Cambridge to Huntingdon improvement scheme

HE/A14/EX/74

Response to the A14 Agents Association's Written Summary (submitted at Deadline 5, 22 July 2015)
of Oral Submissions made by the A14 Agents Association,
the National Farmers Union and Camilla Horsfall of Carter Jonas at the first
Issue Specific Hearing on the Draft DCO (held on 15 July 2015)

3 August 2015

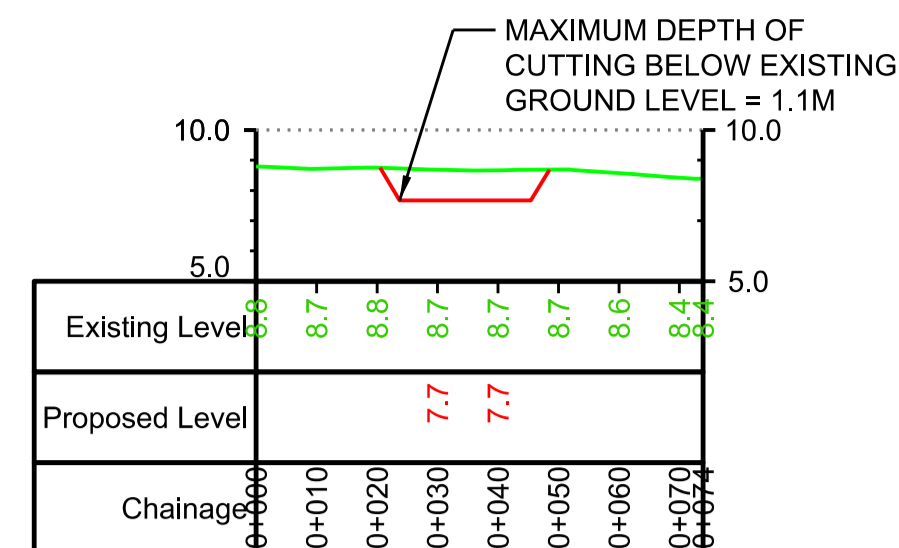
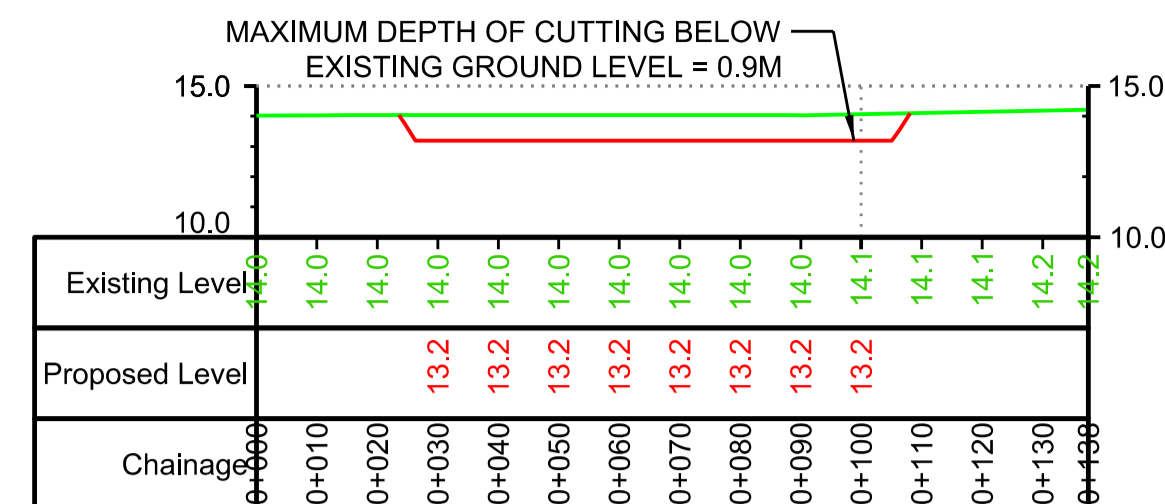
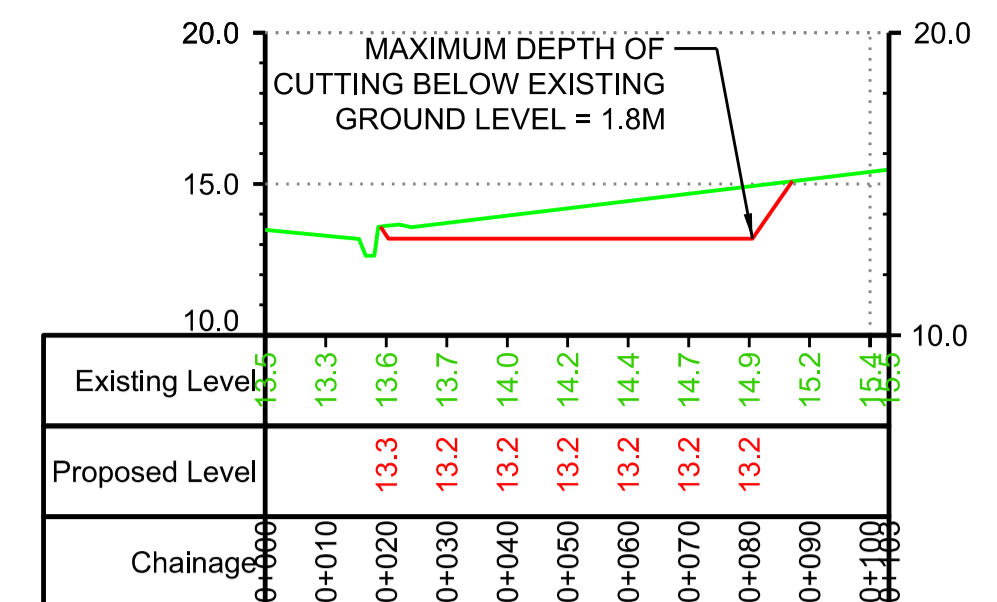
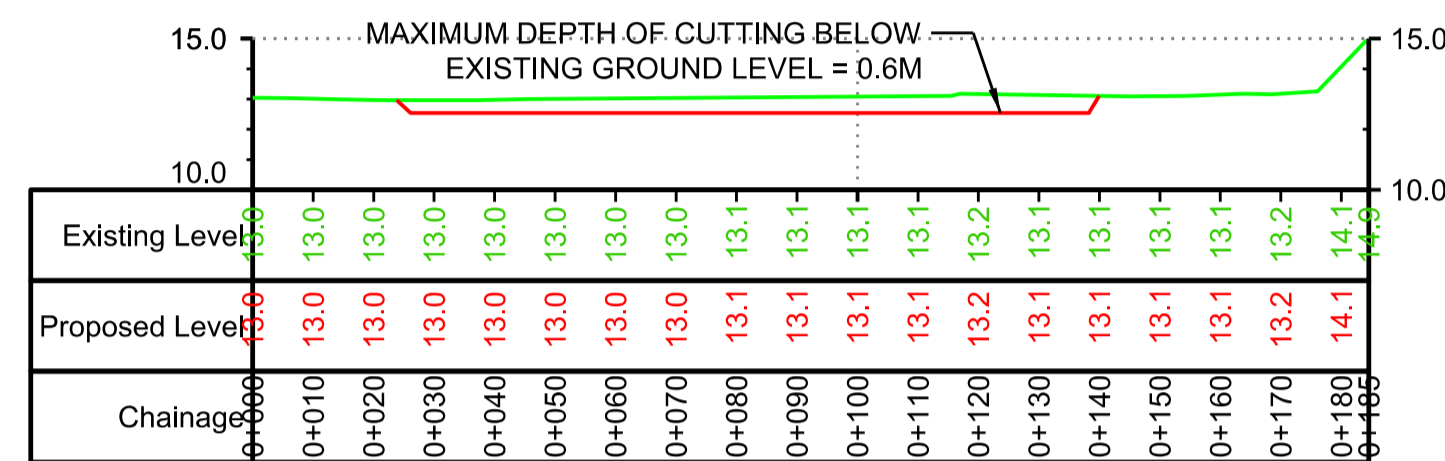
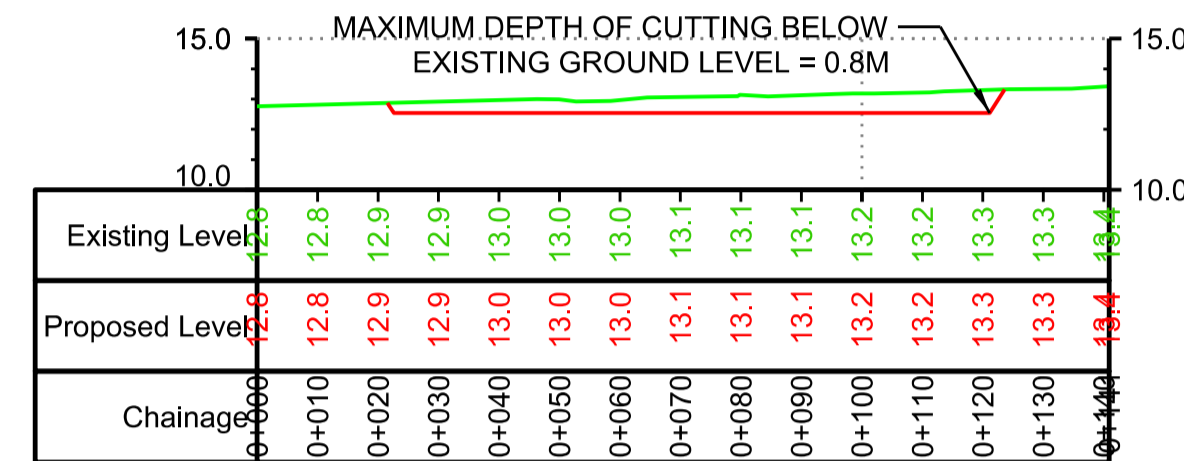
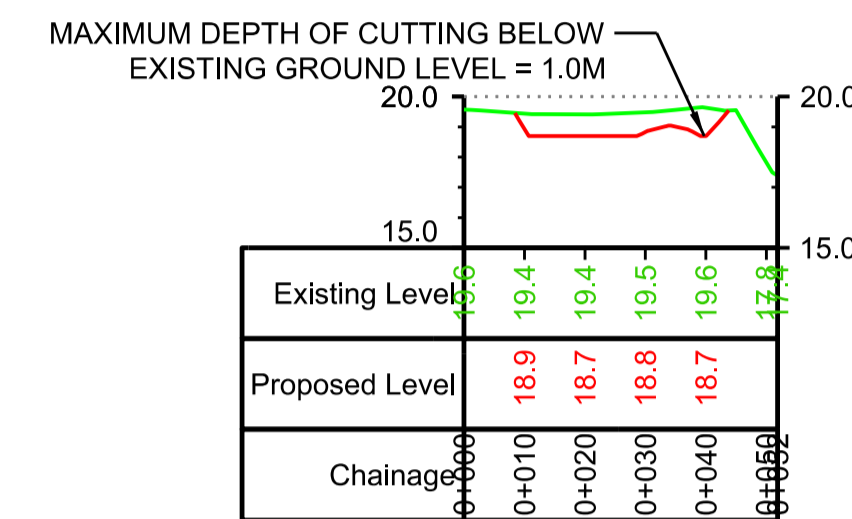
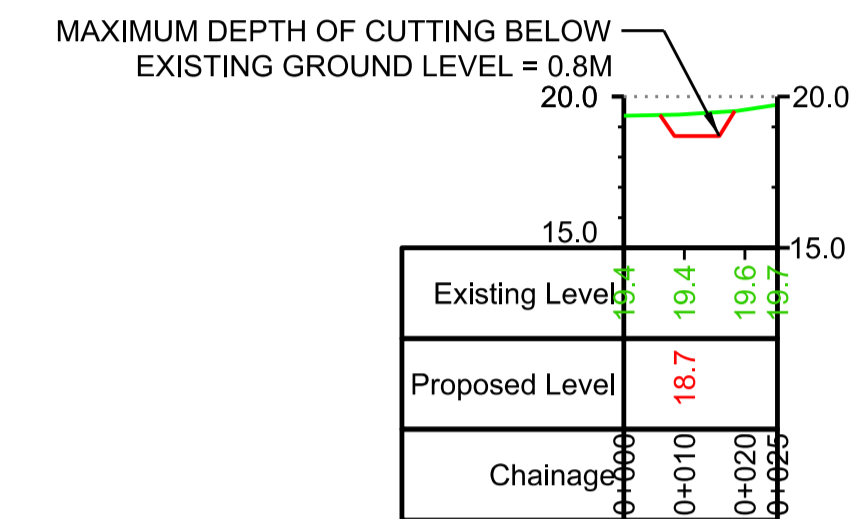
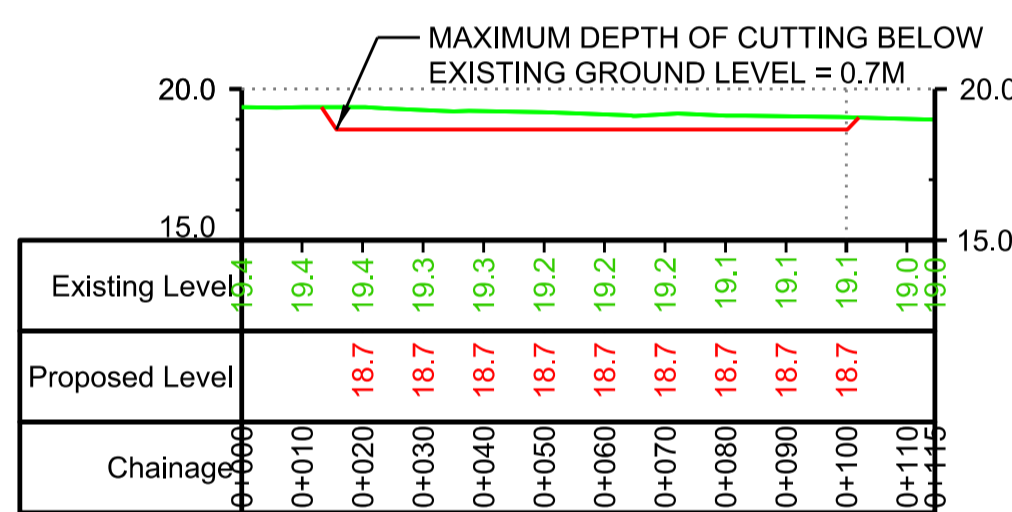
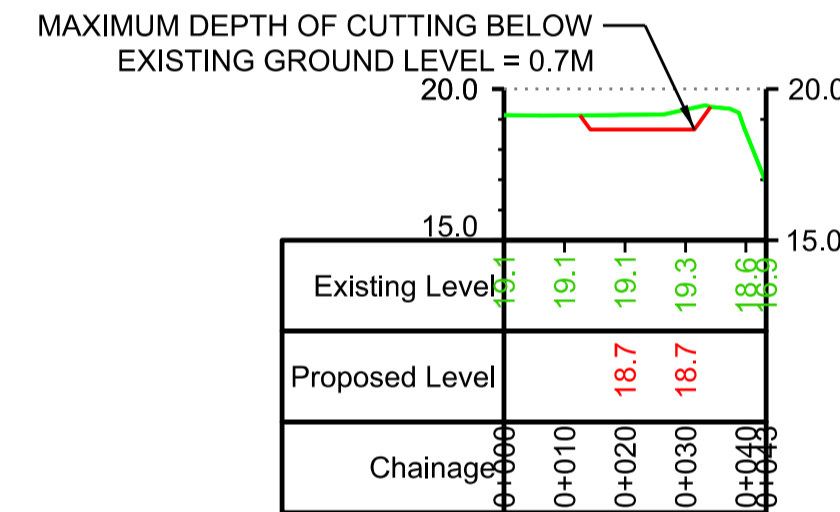
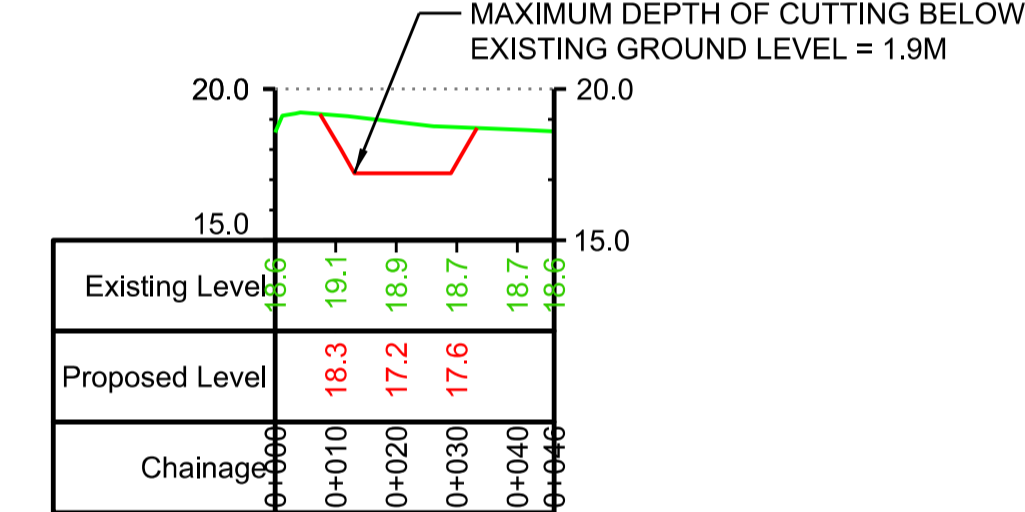
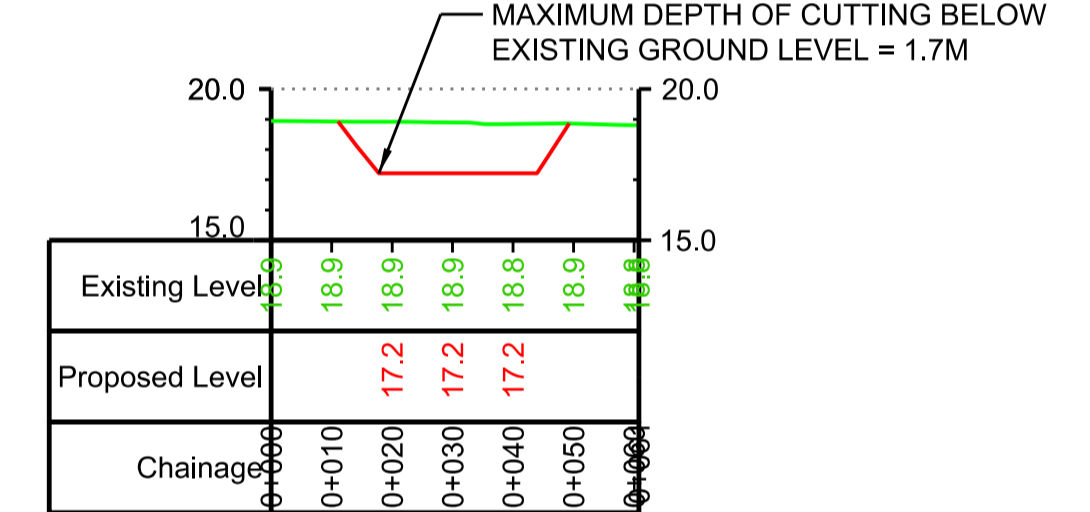
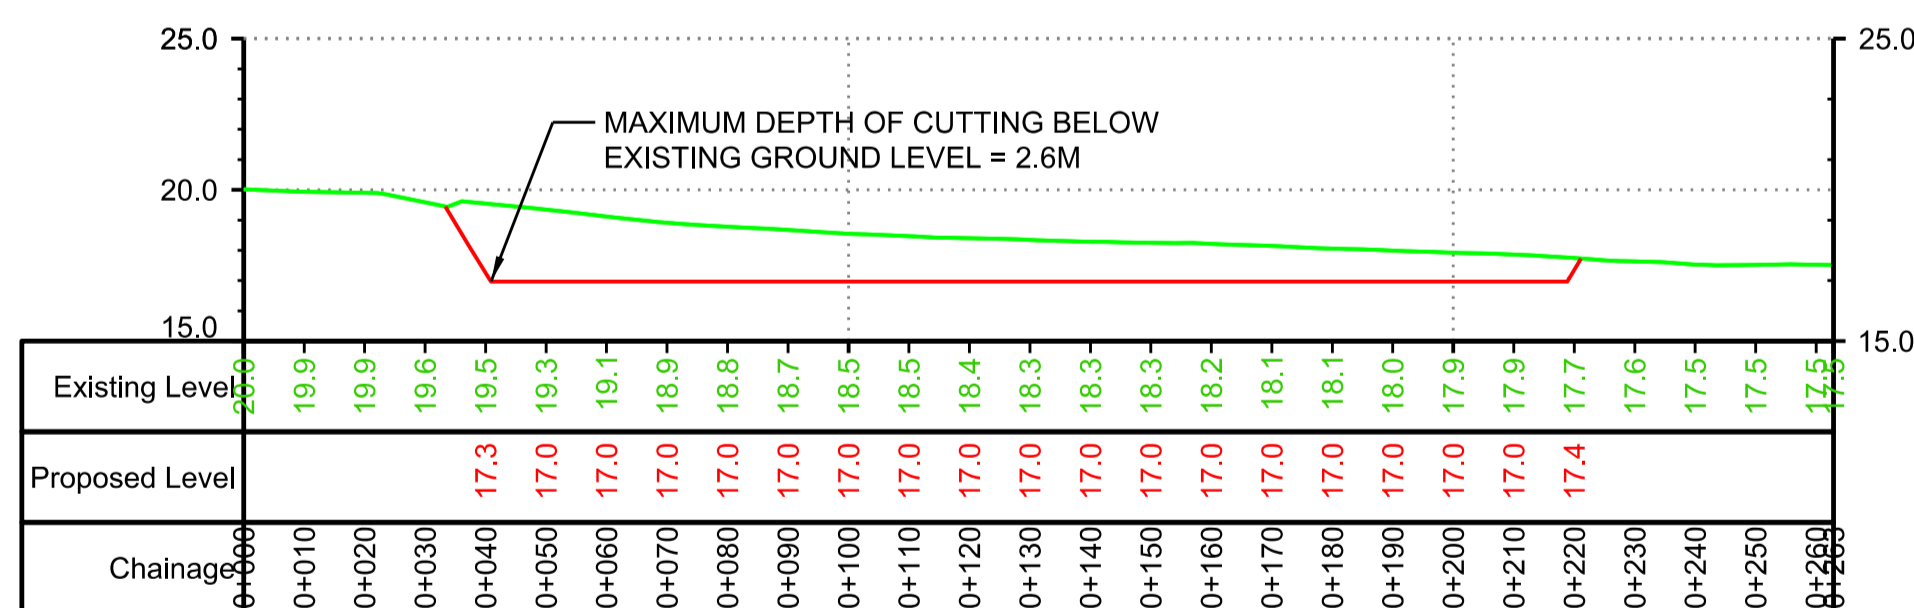
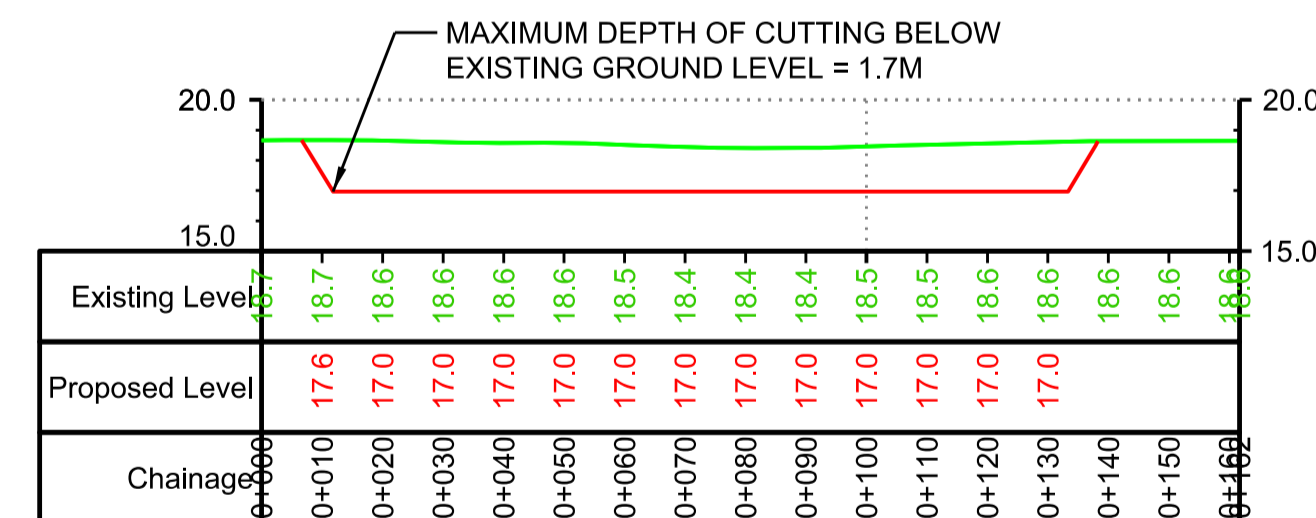
Key Topic	Issue raised by A14 Agents Association, Camilla Horsfall and the National Farmers Union	Highways England Response
Water	<p>The extent of land to be acquired for flood compensation areas and the proportionality to the areas of land taken for the road. This should take into account the existing drainage infrastructure, particularly at Brampton.</p> <p>Inconsistency of responses to Environment Agency and to the National Farmers Union where similar issues have been raised.</p>	<p>The floodplain compensation areas have been designed to replace the existing floodplain lost as a result of the scheme. Their size is determined by the volume of floodplain loss but also the level at which floodplain is lost. The volume of floodplain compensation provision has to be provided at the same level as the current floodplain provision to ensure it operates (fills) on a flood event occurring. Consequently it is necessary to excavate ground outside the floodplain to the required level which means the extent of the floodplain compensation is sometimes larger than that lost as a result of the road.</p> <p>With specific reference to Brampton, the Flood Risk Assessment demonstrates that through the provision of mitigation measures the scheme will not exacerbate flooding in the town downstream from the watercourses that flow through it.</p> <p>The draft DCO scheme design aims to preserve existing drainage where possible or make suitable diversions to maintain the existing land drainage regime. Where the construction of the proposed road causes existing land drainage systems to be severed, head drains would be laid to collect the land drainage flows and</p>

Key Topic	Issue raised by A14 Agents Association, Camilla Horsfall and the National Farmers Union	Highways England Response
	<p>The adequacy of the flood compensation provision in the Scheme's design.</p>	<p>Where hydraulic modelling is available, the Flood Risk Assessment (Appendix 17.01, Environmental Statement (document ref: 6.3) (PINS ref: APP-744)) includes an assessment of the impact of the scheme on the 5% (1 in 20 year) or 4% (1 in 25 year) Annual Exceedance Probability event (in addition to the 1%, 1 in 100 year event). The two lower severity events are typically equivalent to the functional floodplain as defined in paragraph 015 of the National Planning Practice Guidance. The Flood Risk Assessment (Appendix 17.01, Environmental Statement (document ref: 6.3) (PINS ref: APP-744)) demonstrates how the scheme would not exacerbate existing flood risk under such events. This assessment is being verified through the additional modelling being progressed during examination. The additional modelling is being progressed to address the comments received from the Environment Agency following their review of the Flood Risk Assessment and their written representations. The programme for this work extends to early October as agreed with the Environment Agency. It is anticipated that this work will enable the refinement of the extent of the floodplain compensation areas.</p> <p>Level for level floodplain compensation has been provided at all locations where the scheme results in a loss of floodplain, up to the design water level of the 1% (1 in 100-year) Annual Exceedance Probability event plus an allowance for climate change. The floodplain compensation areas have been located as close as reasonably practicable to the area of loss to provide the compensation at the same level. It is not always possible to locate the floodplain compensation areas immediately adjacent to the location of loss but they are always connected to the floodplain. These areas are being refined using the updated hydraulic models during examination and will be periodically reviewed by the Environment Agency throughout the examination period with a final update of the Flood Risk Assessment to be agreed in early October..</p> <p>In summary, with reference to section 1.8.2 of the Flood Risk Assessment (Appendix 17.01, Environmental Statement (document ref: 6.1) (PINS ref: APP-744)):</p> <ul style="list-style-type: none"> • Table 23.1 of the Flood Risk Assessment (Appendix 17.01,

Key Topic	Issue raised by A14 Agents Association, Camilla Horsfall and the National Farmers Union	Highways England Response
	<p>Removal of best and most versatile agricultural land from agricultural production and use as flood compensation areas.</p>	<p>Floodplain compensation has to be provided at the same volume and level as that lost and as close as practicable to the location of loss. The extent of the floodplain compensation areas has been determined by the level at which the flood storage volume has been lost as a result of the construction of the road as required by the Environment Agency to ensure the scheme does not displace flood water. The depth of the floodplain compensation areas varies across the scheme and in the vicinity of Weybridge Farm is shown as being a maximum of 3.2m below existing ground levels as shown at Sheet 54 of the DCO submission Engineering Sections Drawings (drawing ref A14-ARP-ZZ-00-DR-Z-04054) (PINS ref: APP-251).</p> <p>It may be possible to return the area to its current use providing the ground levels are not altered through farming. It is likely this will require the provision of a covenant on the land and the designation of these areas as floodplain which will restrict their future use. The ground level information can only be confirmed following the completion of the detailed design.</p>

<p>There have been inconsistencies in the extent and depth of flood compensation areas since April 2014.</p>	<p>During summer 2014, the Environment Agency produced a revised flood risk assessment. This assessment resulted in the revised approach, in the scheme, to flood compensation areas and to the River Great Ouse Crossing at Buckden-Offord. Highways England held information events in Buckden, Offord, Brampton and Godmanchester to communicate the revised approach to flood compensation to interested parties. The affected landowners were contacted directly to advise them of the need for these changes.</p>
	<p>The impact of taking large areas of land for the scheme on the farmed environment has not been adequately considered.</p> <p>A greater amount of two-way dialogue is required.</p>	<p>Floodplain compensation areas are included in the scheme to ensure that the scheme does not displace floodwater and increase flood risk elsewhere. As stated above, floodplain compensation needs to be provided at the same level as that lost and not just the same plan area or volume to ensure it operates at the same time during a flood event.</p> <p>The draft DCO scheme seeks to retain existing drainage infrastructure wherever possible. It provides mitigation for the additional runoff produced by the scheme before connecting into the existing drainage network.</p>

Key Topic	Issue raised by A14 Agents Association, Camilla Horsfall and the National Farmers Union	Highways England Response
		<p>convey them to the nearest watercourse.</p> <p>The design of the floodplain compensation areas is based on the best available information. As additional topographic information becomes available through the detailed design process the floodplain compensation areas may be refined and so reference would be made to the refined layout. In light of the ongoing technical discussions with the Environment Agency relating to hydraulic monitoring, Highways England considered it appropriate to provide the Environment Agency with an update on progress of this work</p>
	<p>The impact, if any, of further hydraulic or topological studies during the detailed design stage on the extent of land to be compulsorily acquired for flood compensation.</p> <p>As further refinement will only take place after the DCO examination has completed, areas of flood plain compensation areas which landowners find burdensome and detrimental to their farms should not simply be compulsorily acquired.</p>	<p>As stated at page 14 of Report 3 of Highways England Response to Written Representations from the Environment Agency (document ref HE-A14-EX-25) (PINS ref: REP4-013), the hydraulic models used to assess the flood risk impact of the scheme are being refined during the examination period to address the Environment Agency's review comments. This process may lead to the refinement of the floodplain compensation areas. Additionally the areas will be refined further during the detailed design phase following the making of the DCO (if the application is granted).</p> <p>Discussions held between Highways England and landowners during the detailed design process will inform the outcome of the detailed design process. Highways England's intention is to acquire only the land which is actually required to deliver the scheme; however, any land compulsorily acquired, which is later found not to be required for the scheme due to detailed design development would be offered back to the original landowner.</p>

Key Topic	Issue raised by A14 Agents Association, Camilla Horsfall and the National Farmers Union	Highways England Response
		<p>Environmental Statement (document ref: 6.1) (PINS ref: APP-744)) demonstrates how the carriageway level will be above peak design water levels at each watercourse to ensure it will be safe for users during times of flood;</p> <ul style="list-style-type: none"> • Floodplain compensation areas are provided to replace floodplain storage lost as a result of the road and ensure there is no net loss of floodplain; and • As stated above the Flood Risk Assessment (Appendix 17.01, Environmental Statement (document ref: 6.1) (PINS ref: APP-744)) demonstrates that the scheme will not increase water levels by impeding water flow and therefore will not increase flood risk elsewhere except for three watercourses where this is unavoidable (Ellington Brook, Brampton Brook and the river Great Ouse). In these cases Highways England is seeking agreement to the change on flood risk directly with the landowners. <p>As stated in Report 5 of Highways England's Response to Written Representations (document ref: HE/A14/EX/53) (PINS ref: REP4-015) highway drainage attenuation ponds have been located, as far as reasonably practicable, outside Flood Zone 3 areas. However, in a number of instances this has not been possible due to the flat topography and wide floodplain prevalent along the route, together with the design principle of keeping vertical alignment of the road as low as possible. Any attenuation pond located in Flood Zone 3 would be bunded to ensure no flood water would enter the pond. It would have a primary gravity outfall that would operate in the majority of storm situations as water level in the receiving watercourse would be sufficiently low to allow a gravity discharge from the pond. Dependent on detailed design and confirmation of exact inlet and outlet levels, in exceptional circumstances, to address local constraints, the pond would have a secondary pumped outfall that would operate if the pond were to be flood locked due to inundation of flood plain. This would ensure that flow attenuation would continue to be operational during a combination of extreme weather conditions.</p>
